**From:** BCTAdmin@thameswater.co.uk  
**Sent:** 27 April 2017 10:52  
**To:** Planning  
**Subject:** 3rd Party Planning Application - 6/2017/0624/MAJ

Our DTS Ref: 55053  
Your Ref: 6/2017/0624/MAJ

Re: PLOT 5000, HATFIELD BUSINESS PARK, HATFIELD, HERTFORDSHIRE, AL10 9EZ

Drawing Title  
**PROPOSED LEVELS AND DRAINAGE STRATEGY PLAN**

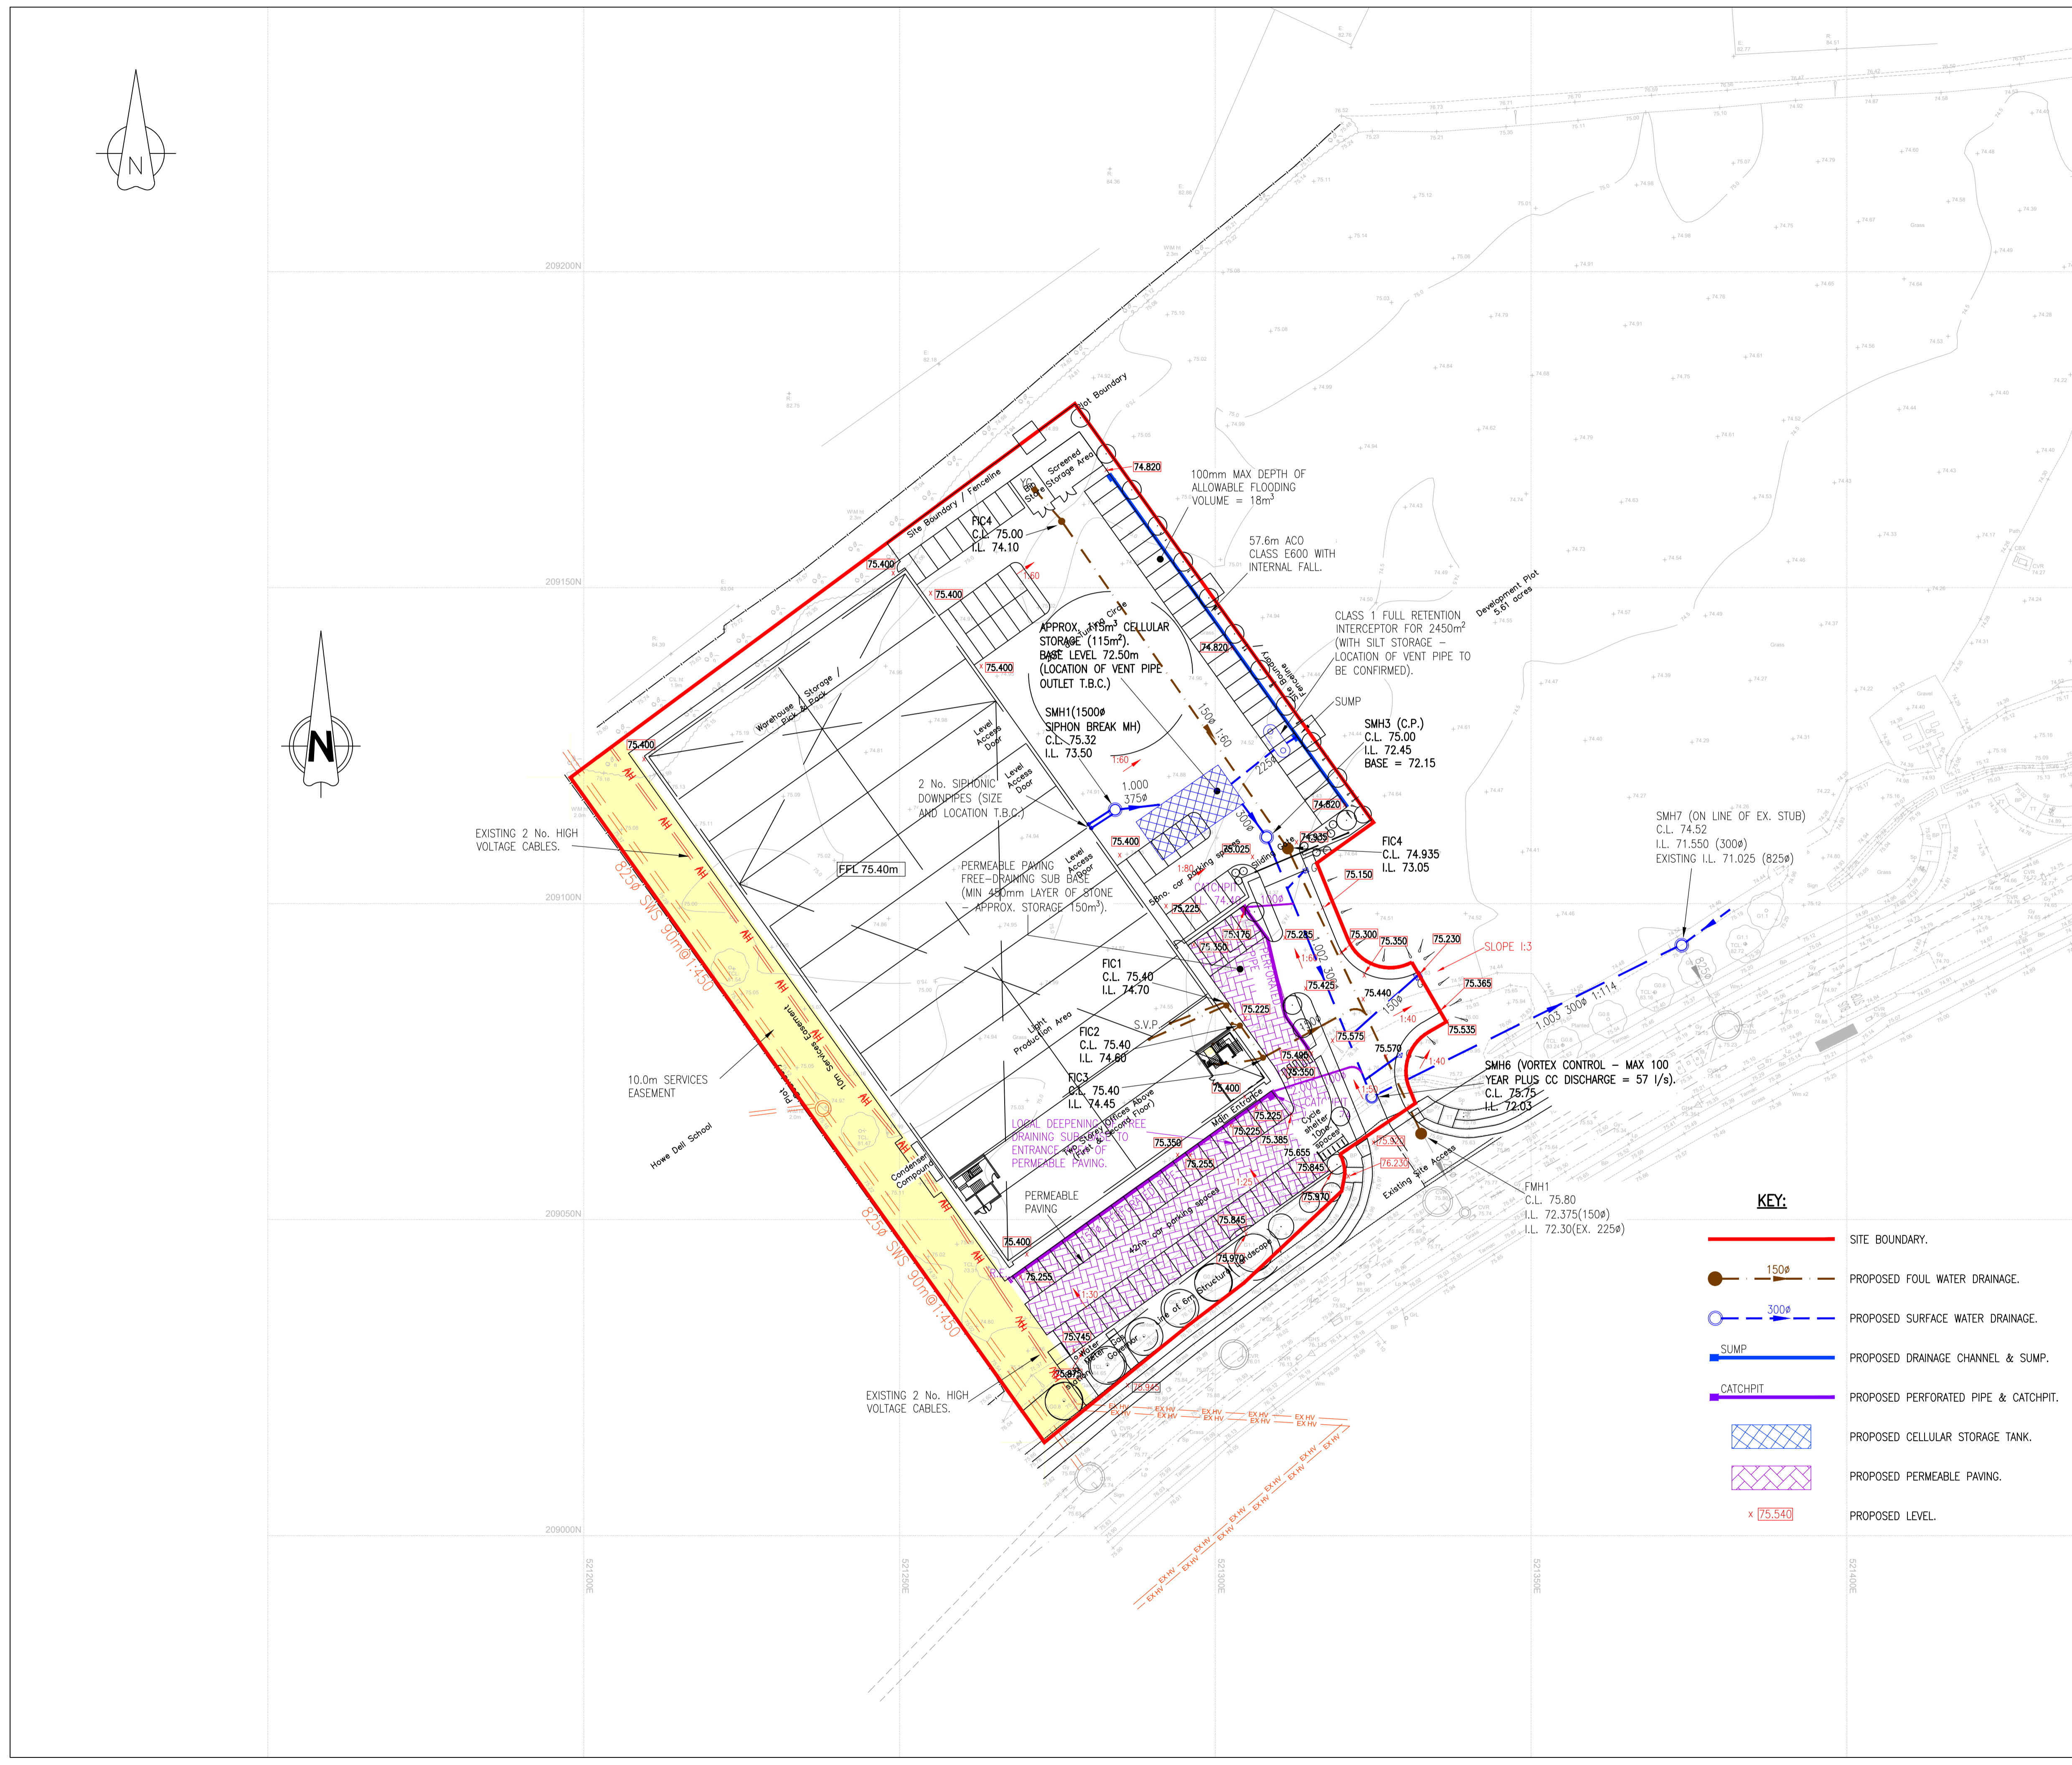
We have no objection to foul water proposal. Regarding surface water: controlling flow rates from sites should be based on Qbar which for this site is equal 2.04l/s. We can accept greenfield runoff rate for 1 in 100 years, which is equal 6.5l/s and not 57l/s. Please recalculate greenfield runoff rate using IH124 method and adjust drainage strategy accordingly.
